Historic England

16 November 2017

**BUILDING 335 HEYFORD PARK CAMP ROAD UPPER HEYFORD BICESTER
OX25 5HB
Application No. 17/02009/F**

PROPOSED SOUTH EAST ELEVATION

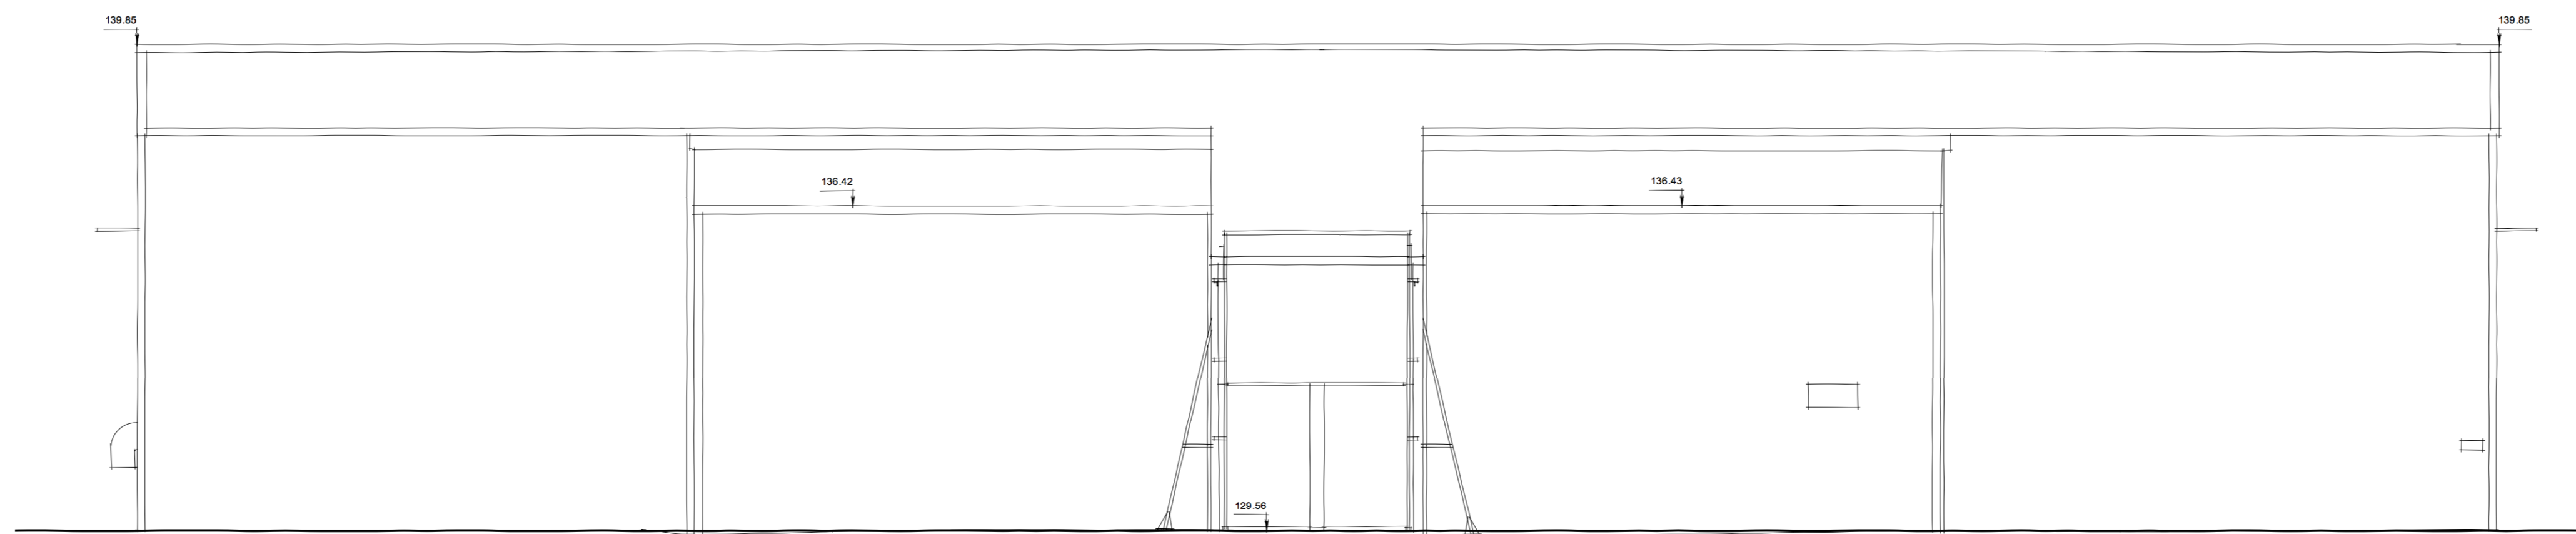
Historic England supports the objective of adapting Building 336 so that it can be made more easily accessible without regularly needing to pull back the full-width sliding doors. Our only observation is that we think this scheme would have less impact on the significance of the building and conservation area if physical alteration to the existing sliding doors could be avoided by rolling them back slightly to allow a central void that can then be filled with the new roller doors - in a similar way to the solution that has already been implemented for the Hardened Aircraft Shelters elsewhere on the site. We encourage you to explore the possibility of

this type of solution before the current application is determined.

Should planning permission be granted, we suggest that the colour of the proposed roller door should be required by condition to match that of the existing sliding doors.
